From: Clare Dales
Sent: 28 February 2018 14:24
To: Richard Temple
Subject: RE: Planning Consultation on: FP/7/18/L

APPLICATION FP/7/18/L

Site Address: Richmond House 47A Felpham Way Felpham PO22 8PT

Description of Works: Listed Building Consent for proposed side extension to non original part of dwelling

02

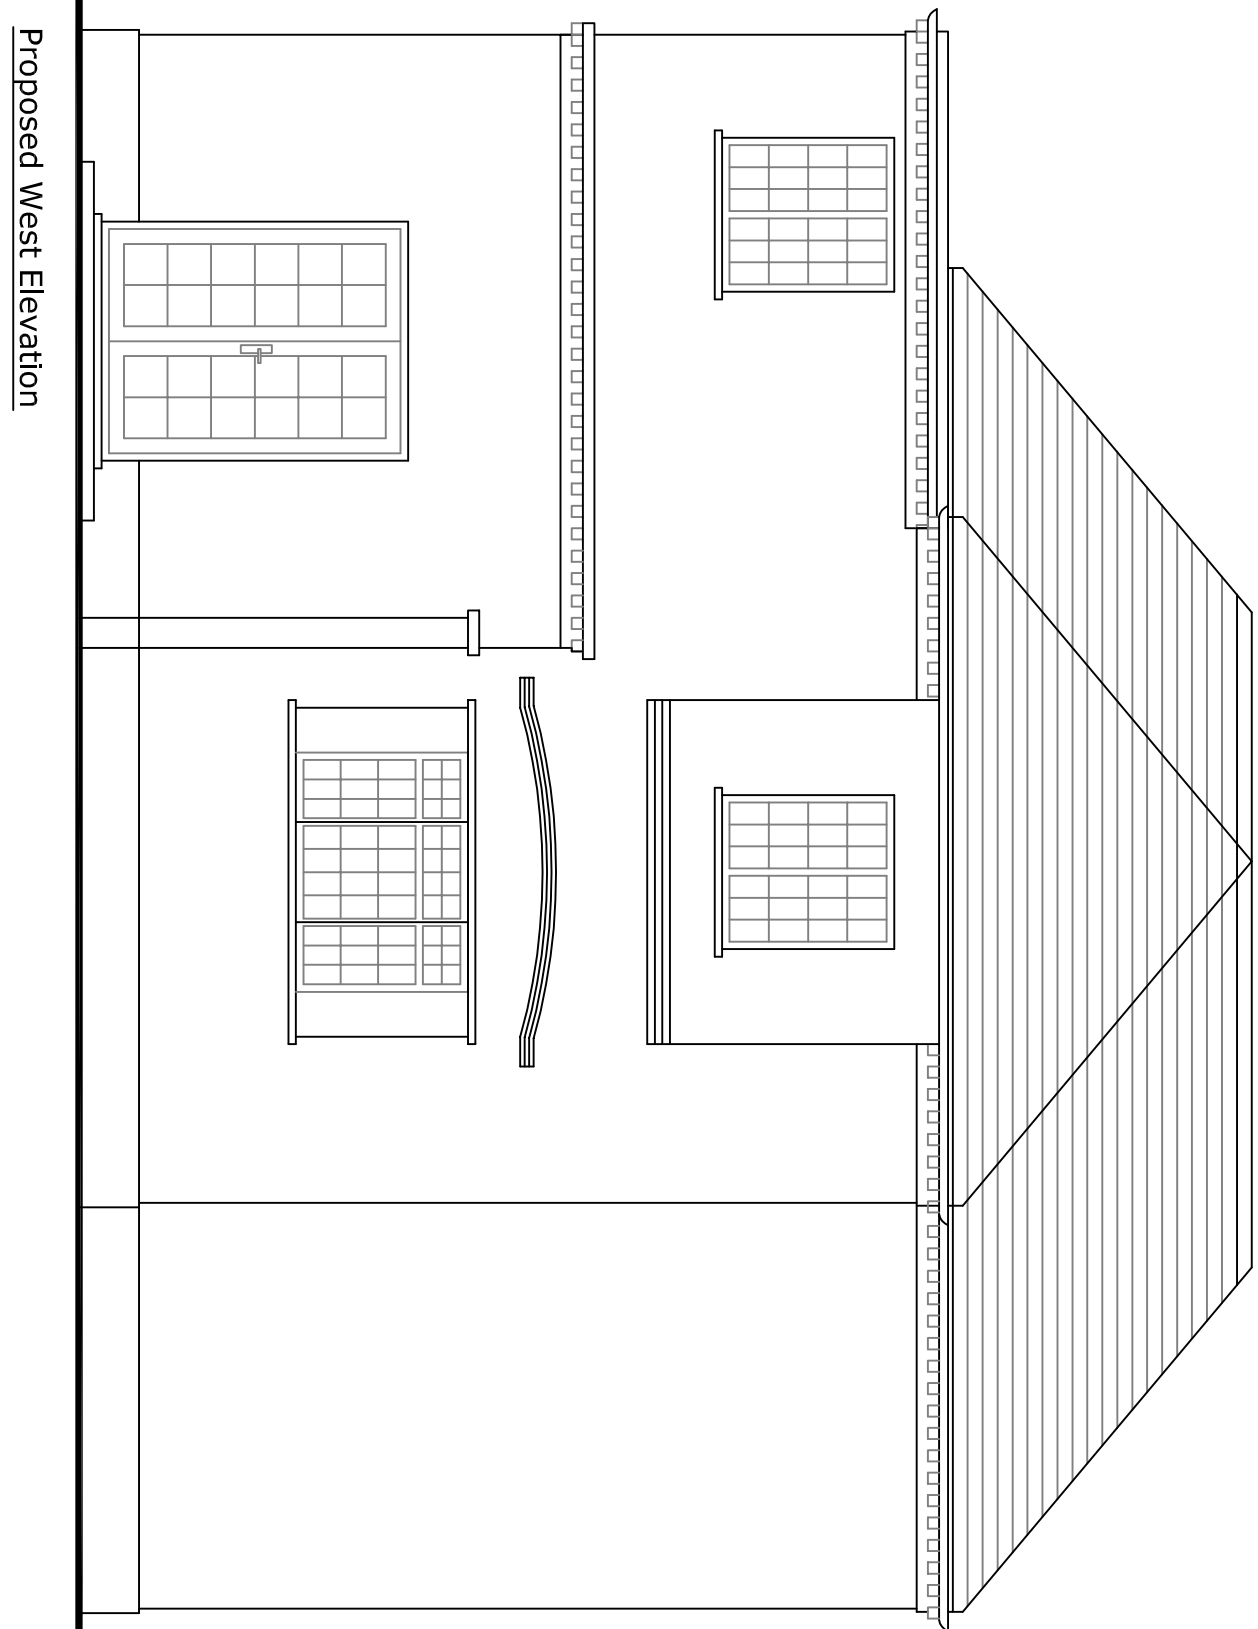
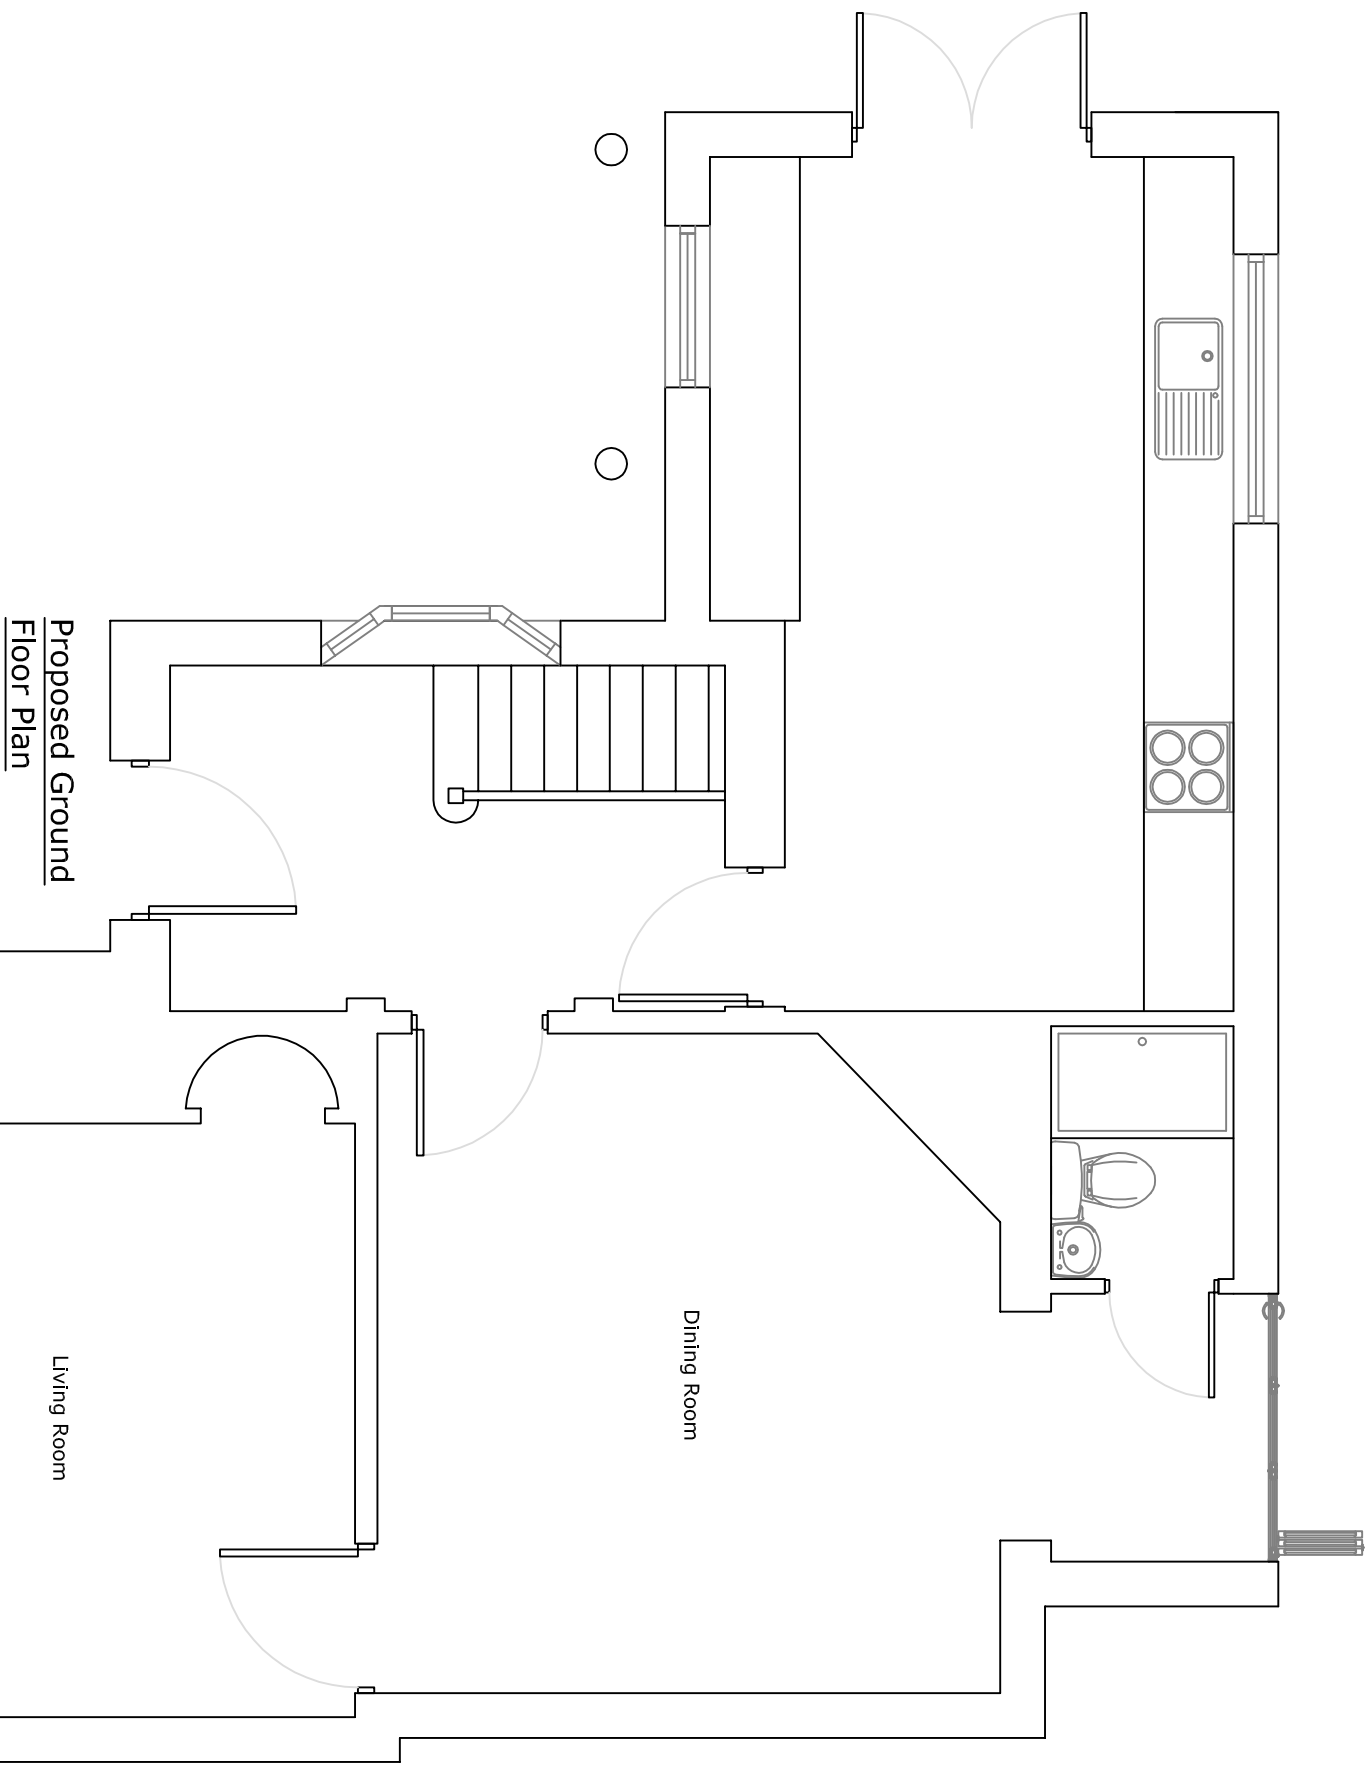
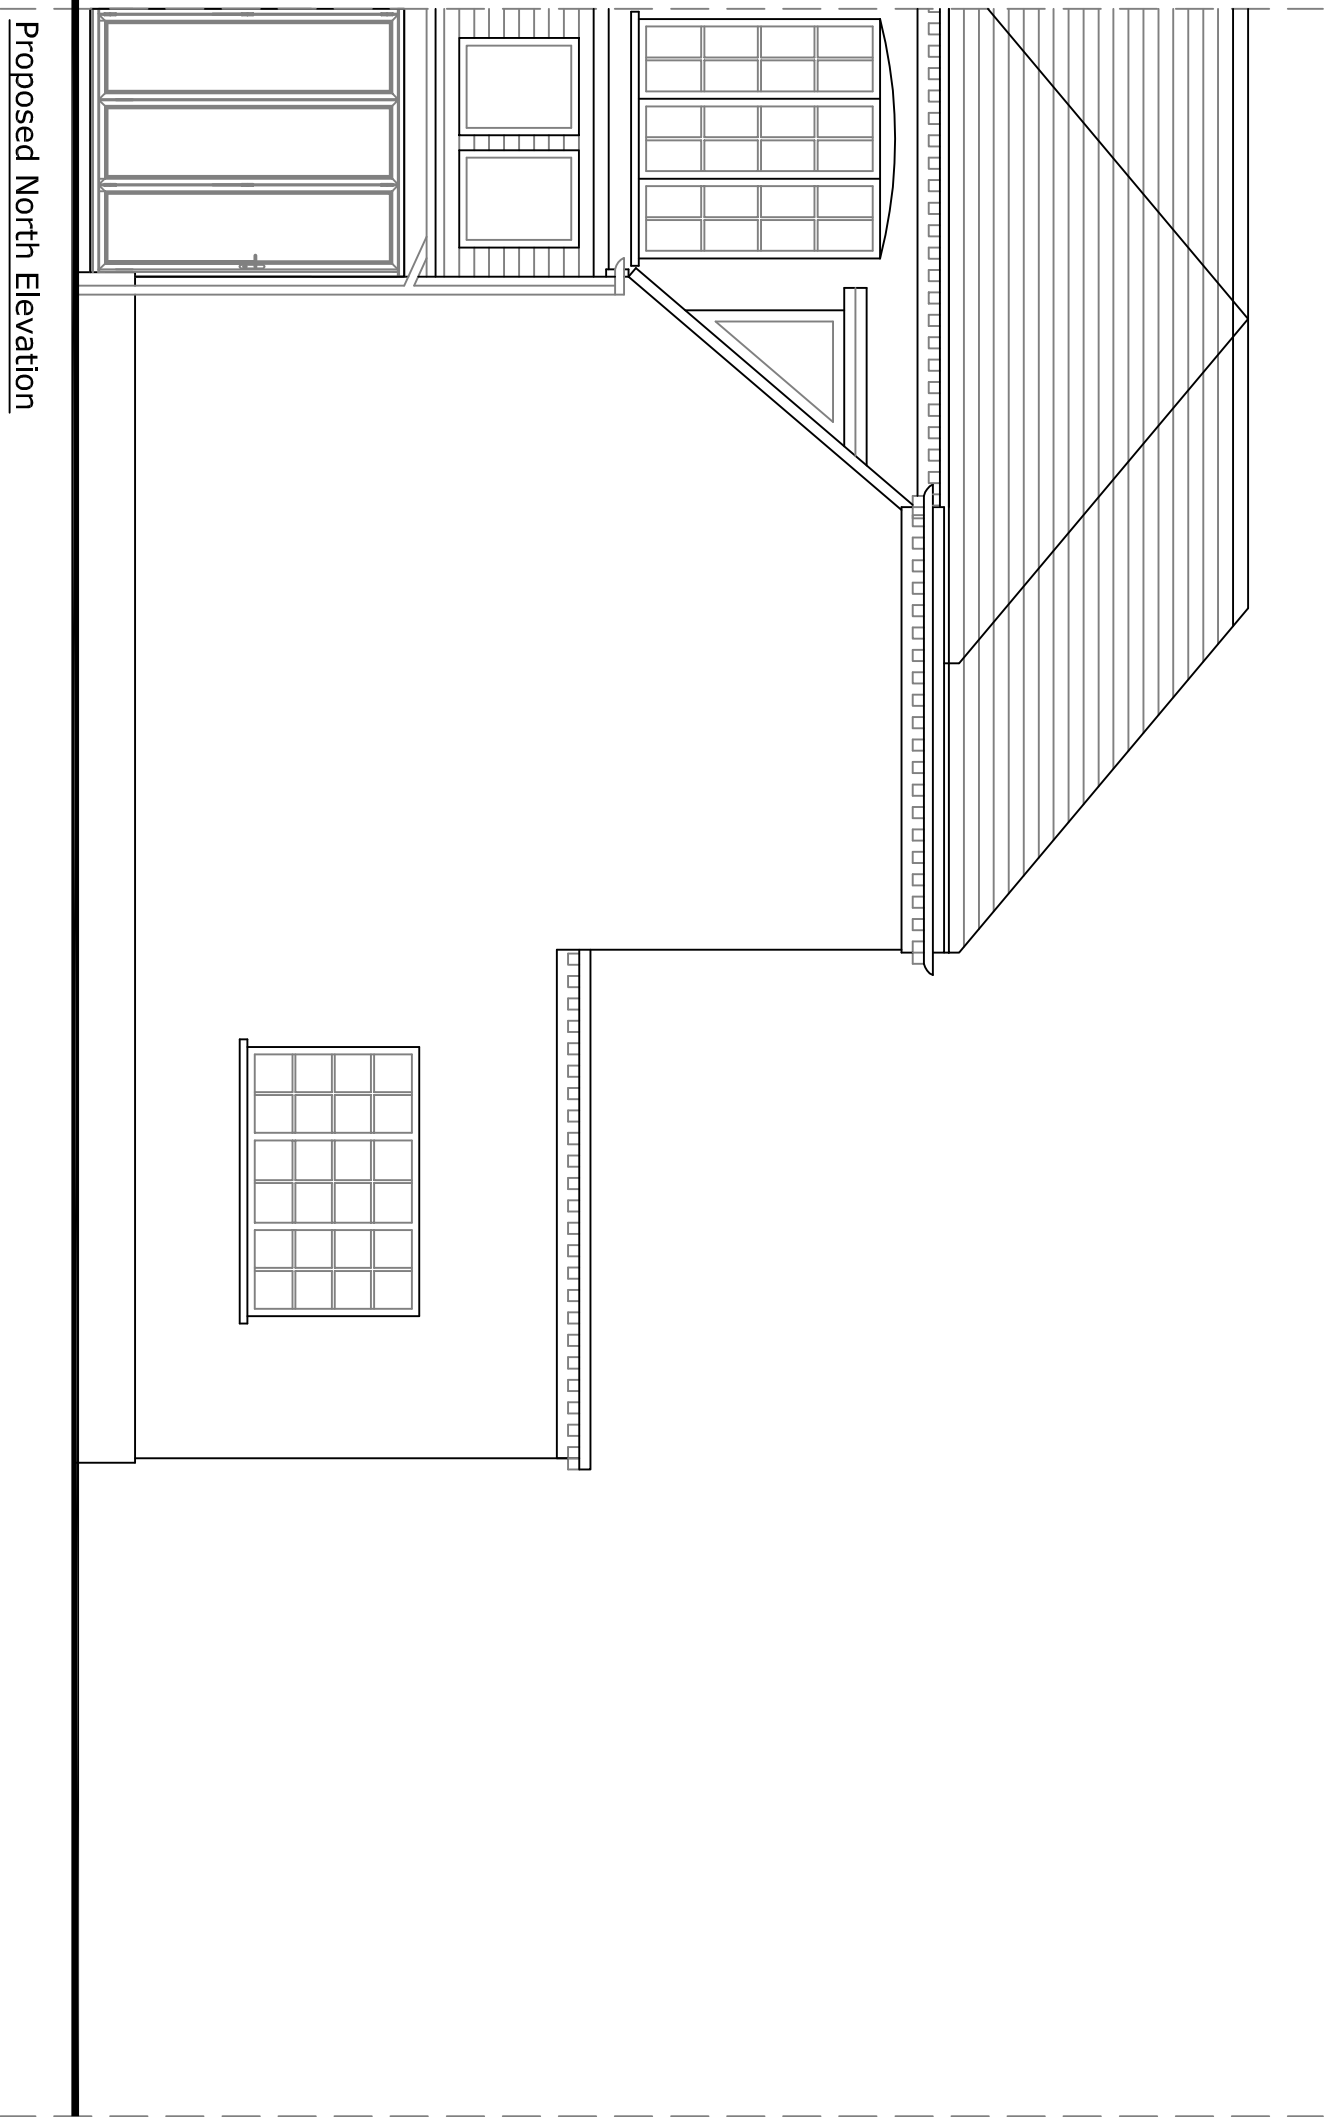
The submitted plans detail an extension, plus a solid wall with door and canopy over. The proposed extension to kitchen is supported in terms of scale, mass, location and detailing, with the exception of the bifold doors as shown on plan. Such glazing is considered out of keeping with the property. It is recommended that a single solid/cottage door be inserted within a solid wall. Fenestration may be introduced.

The solid, freestanding wall with door and canopy is recommended for refusal as this element is dominating, detracts from the main house, its existing (and proposed extension, if approved).

It is noted that the existing and proposed pedestrian and vehicular gates are shown identically. The existing gate as seen during a site visit does not match that drawn, nor would approval be recommended, due to the solid nature of the proposed, and their overly contemporary styling.
